Document DCO 8.3B/MCO 8.3B

Statement of Common Ground between the Applicants and North West Leicestershire District Council (relating to Planning Policy)

~~July~~September 2026

The East Midlands Gateway Phase 2
and Highway Order 202X and The East Midlands Gateway
Rail Freight and Highway (Amendment) Order 202X

Drawing Title
**ILLUSTRATIVE
LANDSCAPE
MASTERPLAN**

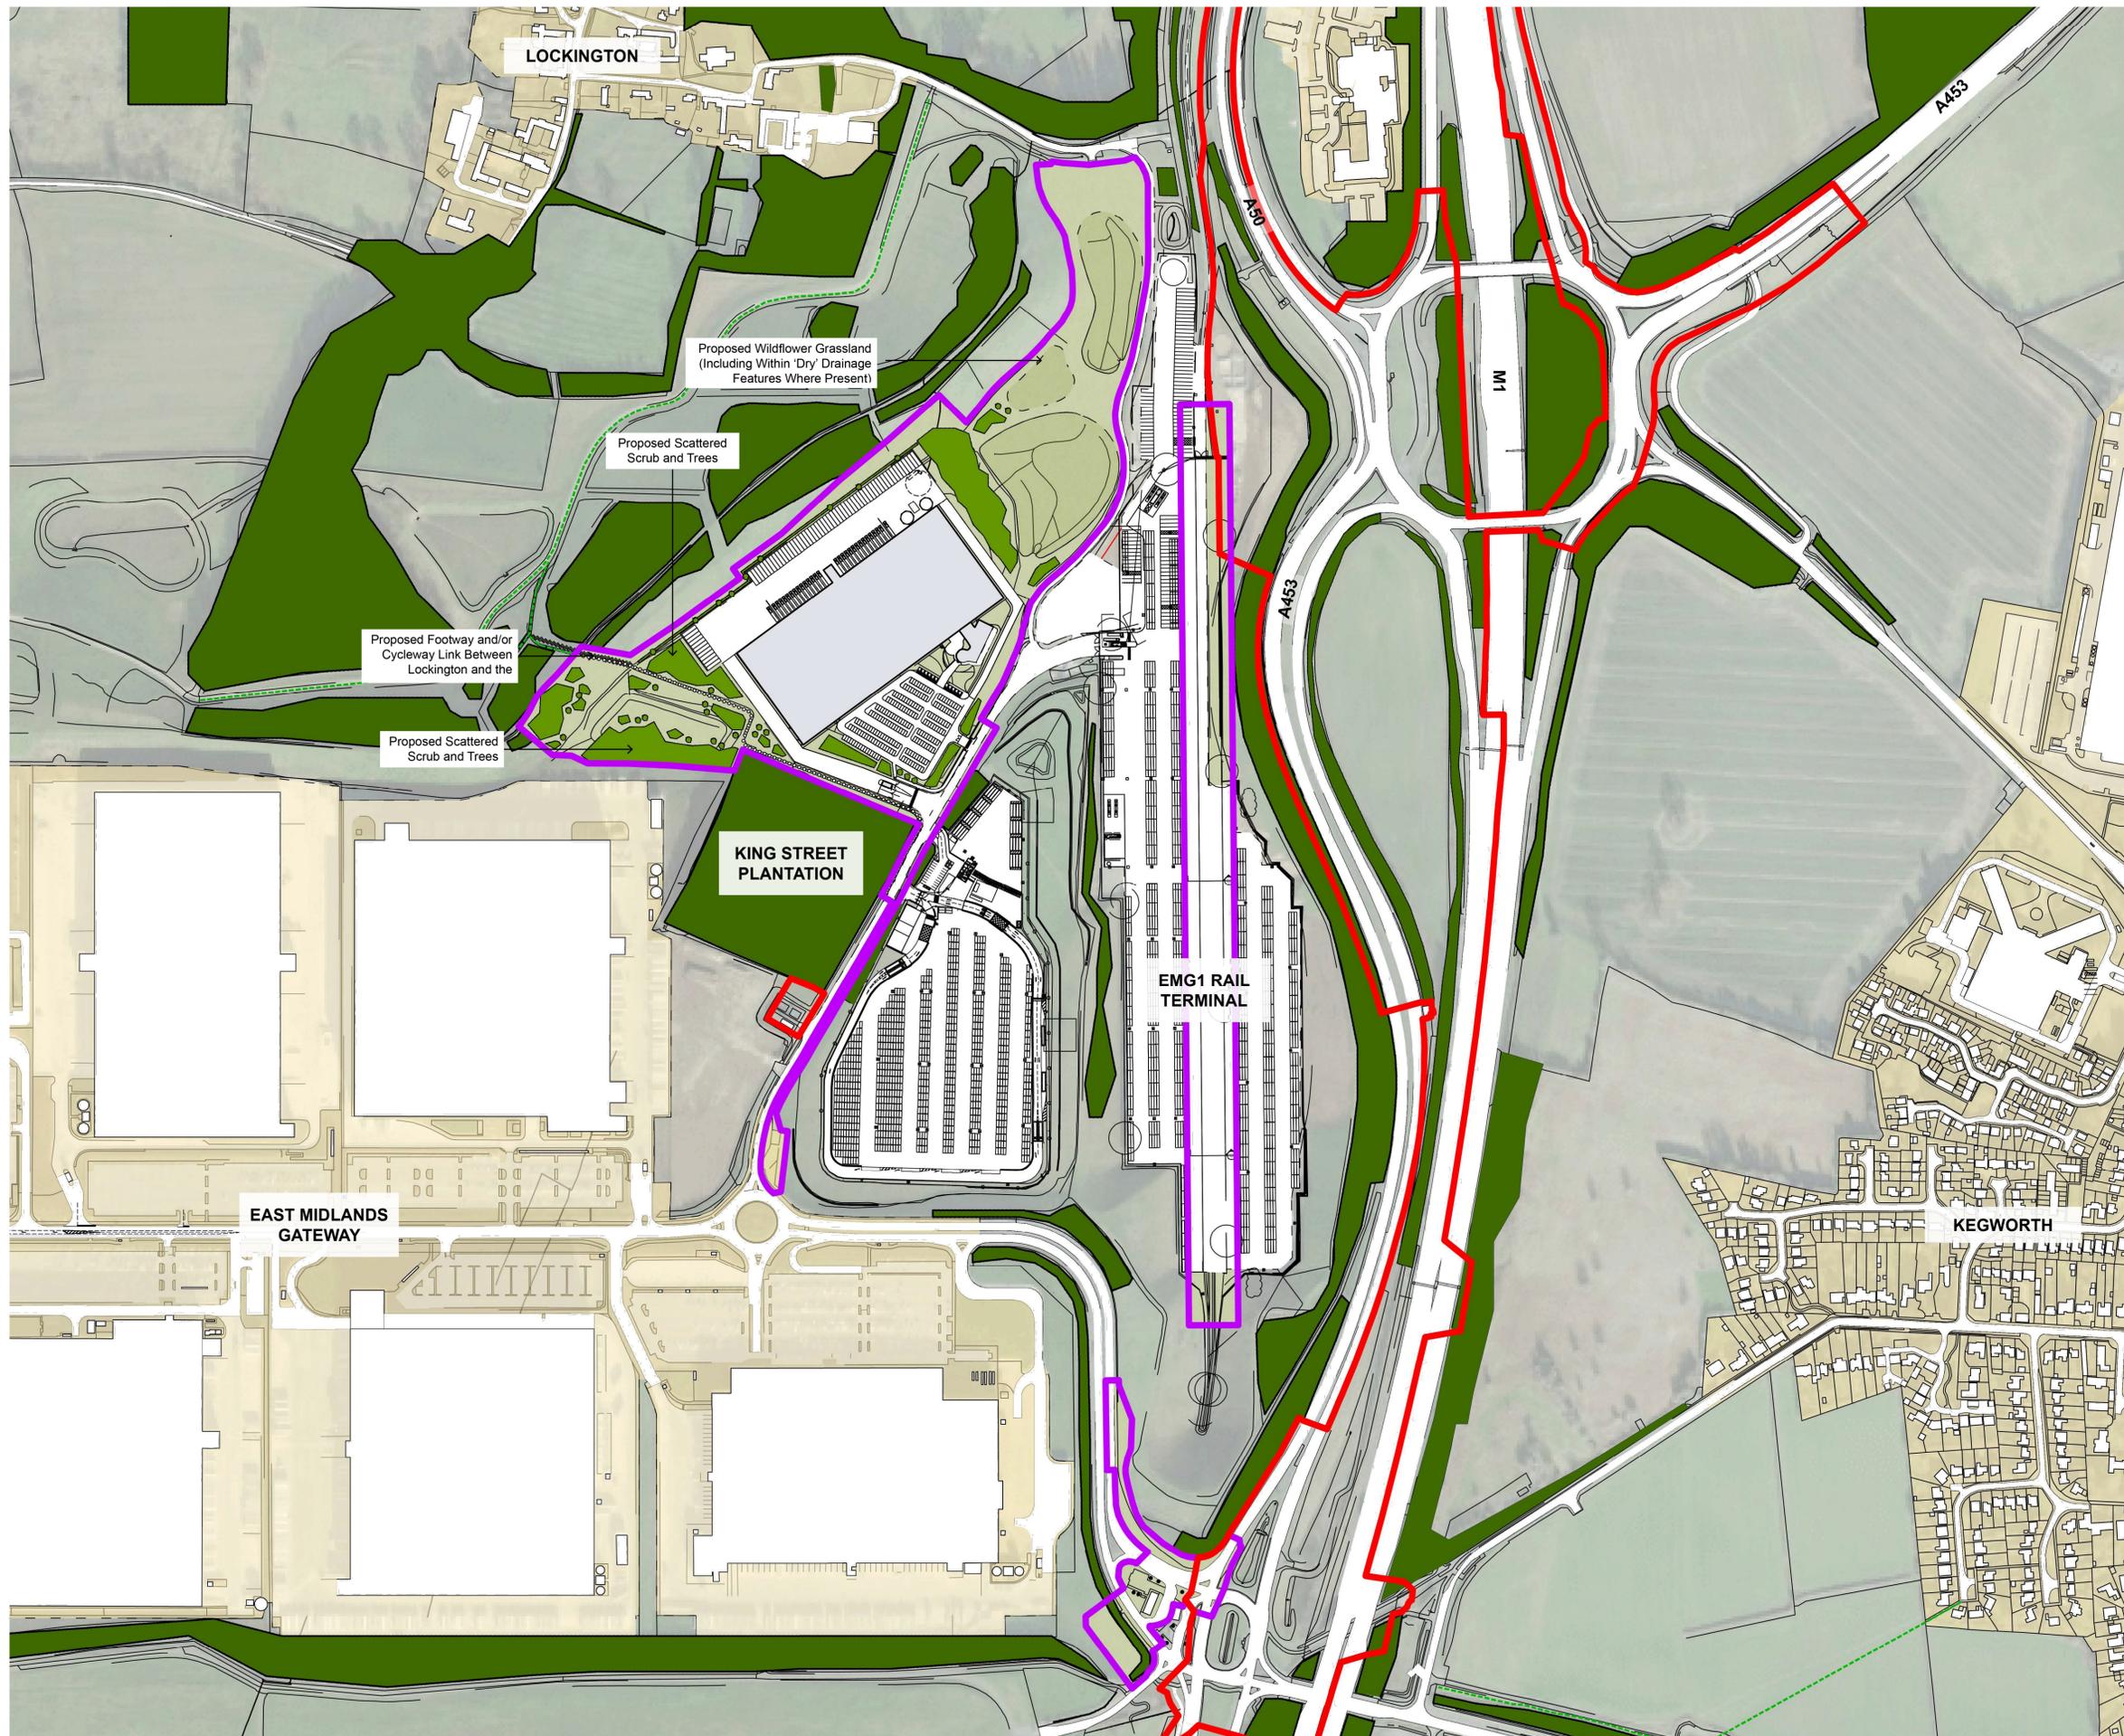
4.13	<u>Safeguarding of land for the dualling of the A453</u> Landscaping along A453 frontage	DCO Parameters Plan (Reference AS-006D) (Reference REP6-006D) DCO Illustrative Landscape Masterplan (Reference AS-048)	<u>LCC has responded to the ExP questions about requirements for dualling to the west of the A453 / Beverley Road roundabout [REP4-006D]. That document (in the section relating to Requirement 31) contains no technical substantiation of the need for dualling across the entirety of the frontage. The only technical work the Applicant is aware of does not substantiate that need as set out in the response to REP4-06D submitted by the Applicants at Deadline 5.</u>	Criterion 2(c)(vi) of Policy Ec3g of the North West Leicestershire Proposed Submission Draft Local Plan (July 2026) requires the following: <i><u>“ensure the site layout incorporates a corridor of land along the entirety of the site’s A453 frontage sufficient to accommodate the additional land required for the dualling of the A453 between the Finger Farm roundabout and the entrance to East Midlands Airport.”</u></i>	Under- Discussion Not Agreed	28/07/01/09/2026

It is the applicant's position that the proposed screening along the A453, as shown on the Parameters Plan and Illustrative Masterplan is robust and appropriate.	<u>The DCO Parameters Plan includes the safeguarding of land between the Finger Farm roundabout and the roundabout junction with Beverly Road but does not extend along the entirety of the site's frontage with the A453.</u> <u>Whilst acknowledging the position of the ExP and the Applicants in respect of this matter, NWLDC support the position of LCC (see 4.8c (Proposed Highways Works – EMG2 Main Site Access) of the Highways and Transport SoCG between the Applicants and LCC [REP6-057]).</u> <u>In NWLDC has noted the Applicants response to Q2.0.6 of the First Written Questions of the ExP (Reference REP1-054) in that an acoustic fence is only required to the site boundary with the A453 if the service yard associated with any unit adjacent to the A453 is presented to the A453 (rather than internally into the site).</u> <u>this respect NWLDC consider that the safeguarding of sufficient land to allow dualling</u>

of A453 along the entirety of the site's frontage is critical to ensuring that the growth anticipated by the draft Local Plan can be delivered. Notwithstanding this, the DCO Parameters Plan and DCO Illustrative Landscape Masterplan do not show land which may potentially be safeguarded for the dualling of the A453 and how this may impact on the landscape buffer to be provided. Additionally, the Applicants did not provide a response to the ExP in relation to the 'minimum' width of the landscape buffer alongside the A453 as was specified within Q2.0.6. NWLDC would require details to be provided in relation to the above points before such time as comments can be provided on the suitability of the landscaping alongside the A453 site frontage.
